WESTERN SYDNEY STADIUM (SSD 16_7534) SECTION 96(2) MODIFICATION APPLICATION SUMMARY OF SUBMISSIONS

Figure 10: Piling Plan (courtesy Lend Lease)

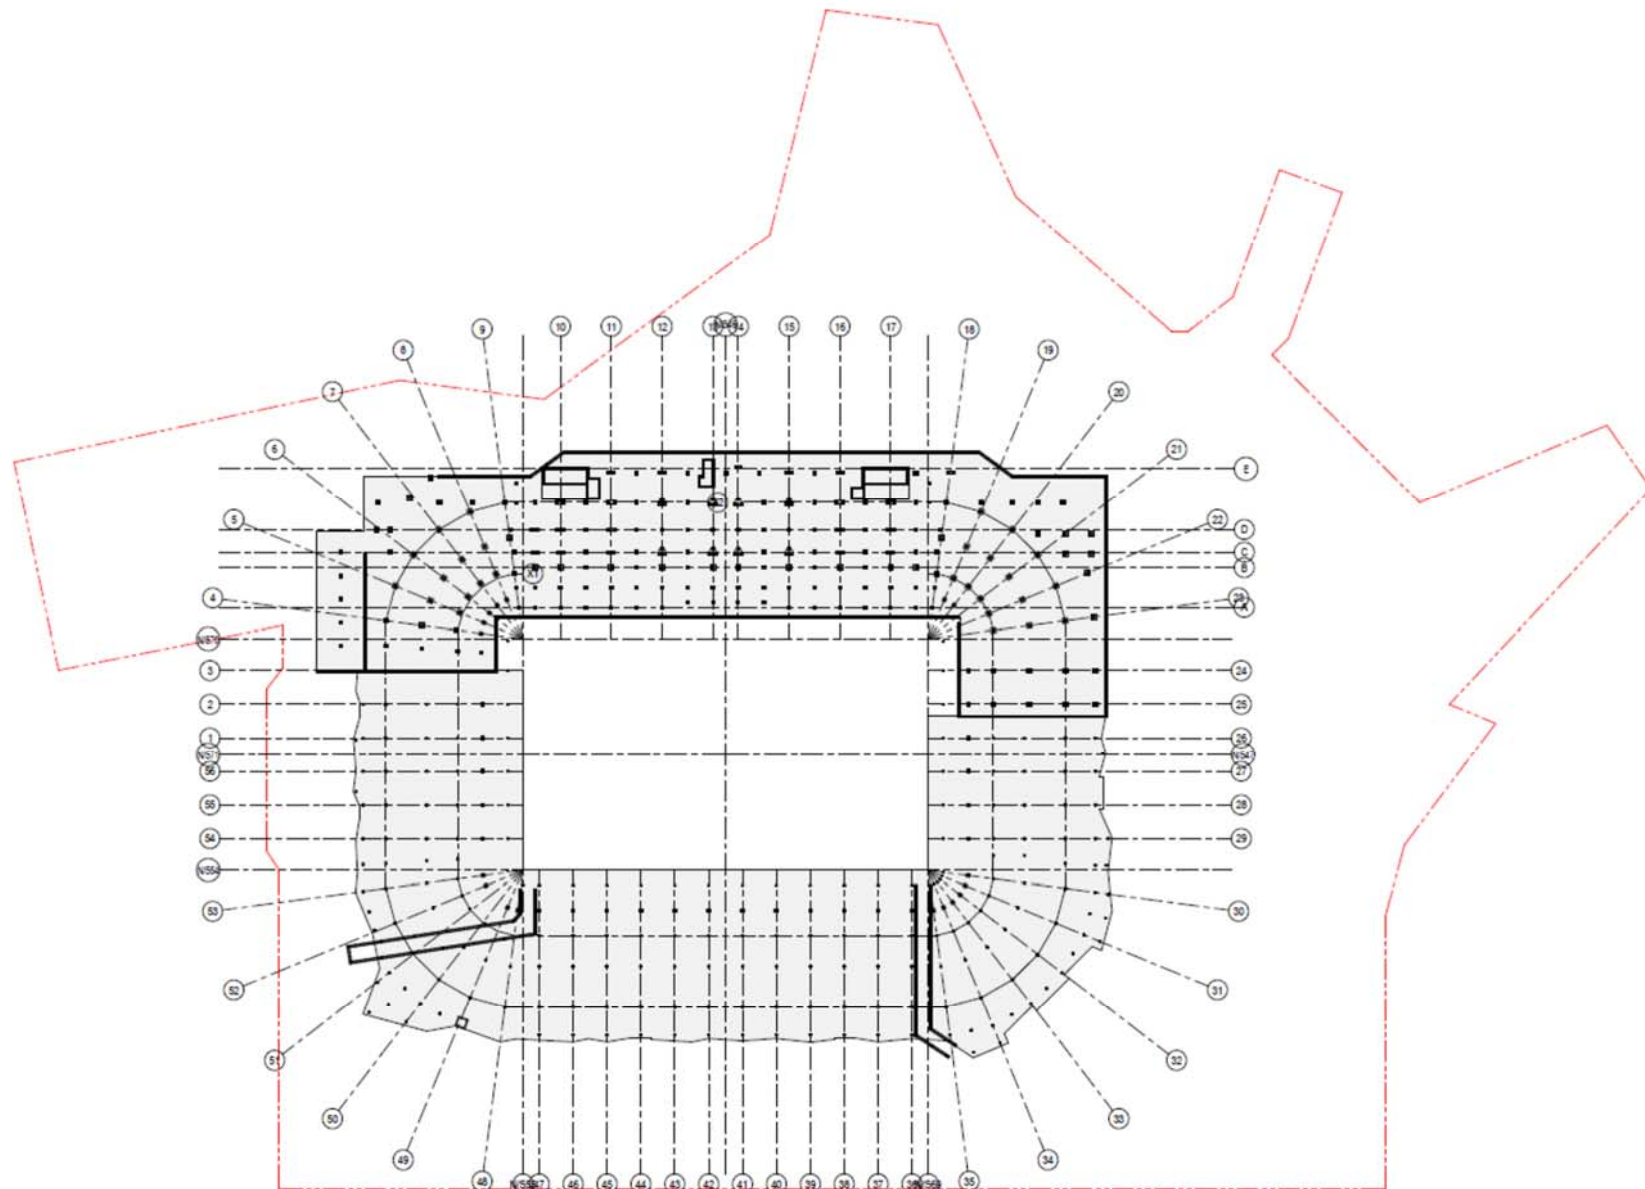
Identify and adopt a less noisy piling method (example: vibro-piling in those areas where bored piling represents an unacceptable safety risk) other than driven piling	As outlined in the response letter prepared by Acoustic Logic, Section 3.3.5 of the Demolition, Excavation and Construction Noise Management Plan the piling method may comprise a combination of bored, precast and Continuous Flight Auger (CFA) piling, these methods are reiterated in the Lendlease Construction Management Plan submitted with the Stage 2 SSDA. Acoustic logic provide that bored and CFA piling are the least intrusive forms of piling for both noise and vibration emissions. Precast piles will be avoided on the eastern property boundary unless deemed necessary to avoid an unacceptable safety risk. It is noted that piling of any kind is not predicted to exceed the "Highly Noise Affected Management Level" or vibration criteria at the nearest affected receivers, given the considerable distance between the piling works and any affected receiver, in all directions.

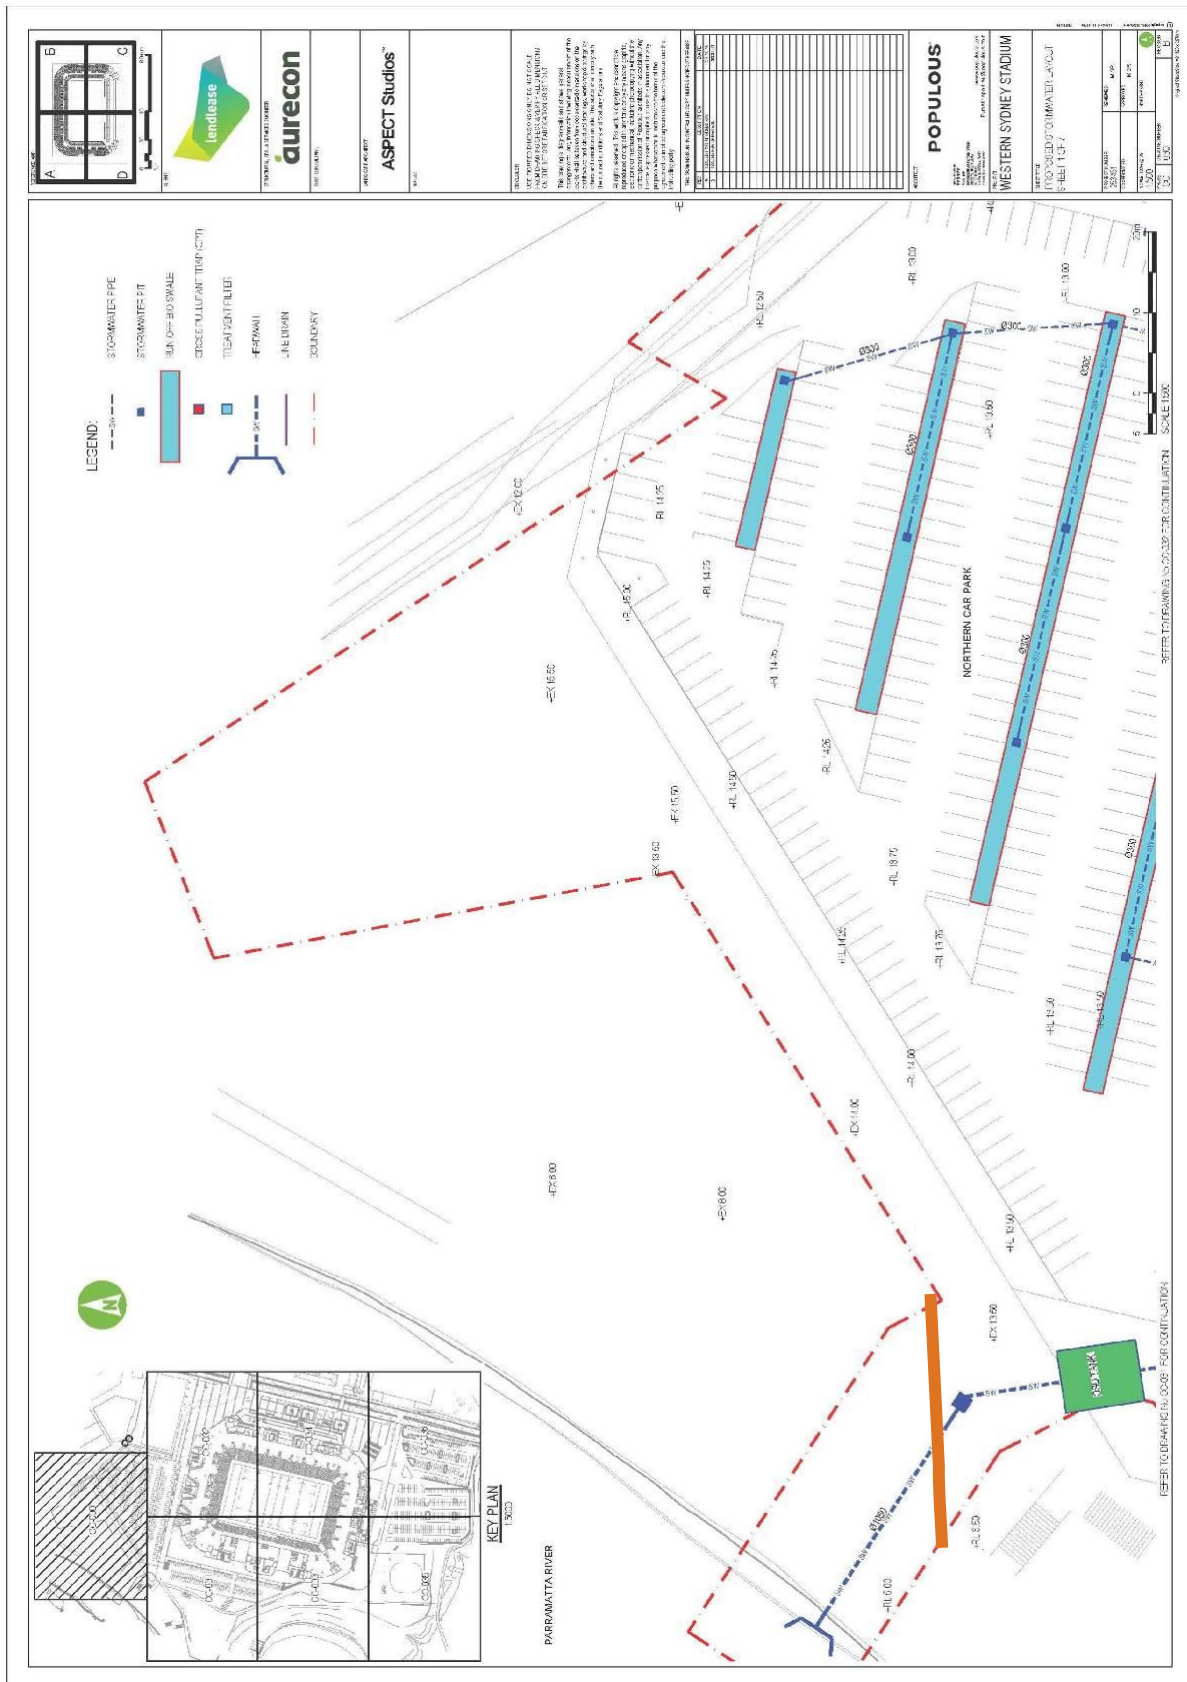
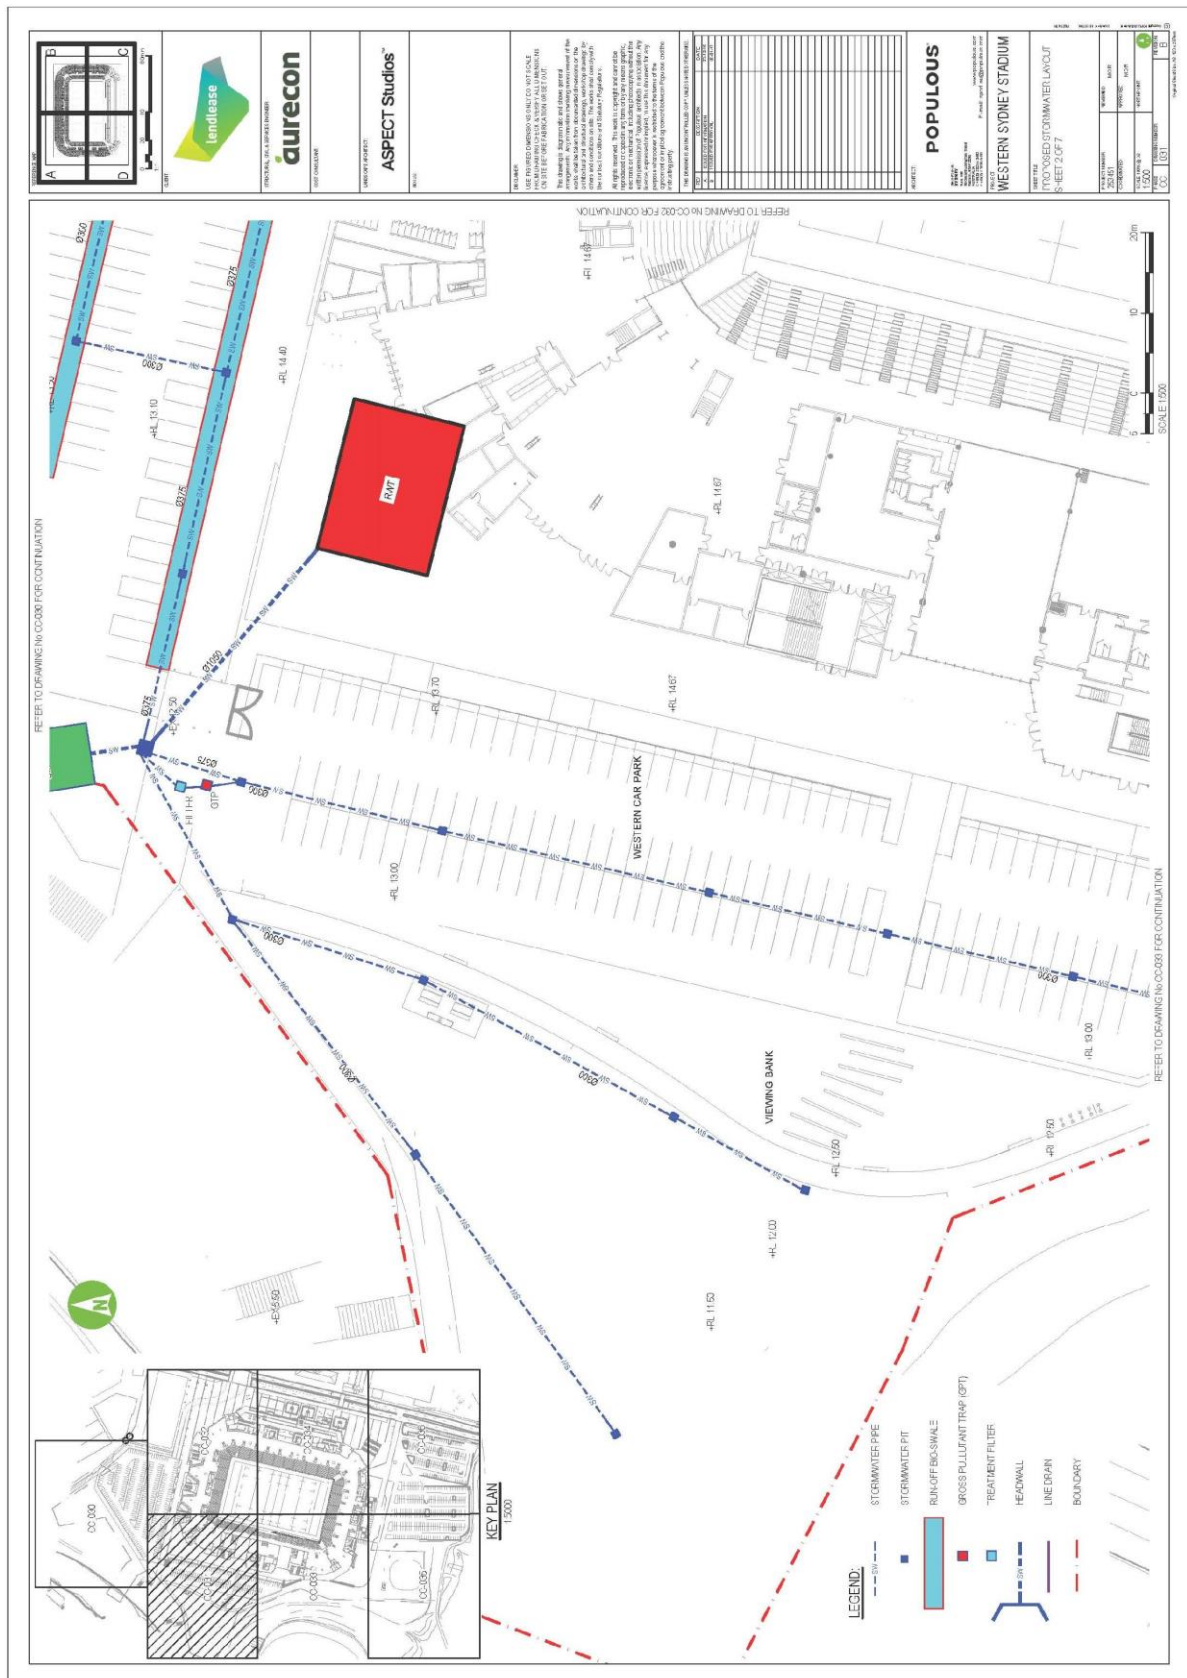
Submission	Summary if Comments	Response
Heritage Division, Office of Environment & Heritage	A stormwater element and outfall into Parramatta River is located within the Parramatta Park and Old Government House portion of the Australian Convict Sites listing	The stormwater plan submitted with the modification illustrates a stormwater line in this location however the stormwater arrangement proposes the re-use of the existing stormwater line that discharges into the Parramatta River. This is not expected to result in any noticeable impacts to OGH.
	The archaeological recommendations are considered appropriate	Noted.
	The RAP does not indicate how archaeological testing can occur within the overall remediation works safely and efficiently.	The RAP is an environment management report and does not intend to specify operations surrounding archaeological management. The archaeological heritage reports specify appropriate management and mitigation measures (supported by the OEH) to protect archaeological heritage. Furthermore, works will be undertaken in accordance with an unexpected finds protocol.

1. All current heritage conditions of approval shall remain unchanged.	Noted, no comment
	2. The stormwater elements, and its outfall into the Parramatta River shall be sensitively designed to avoid the World Heritage Area buffer zone associated with Parramatta Park and Domain.	Noted, no comment
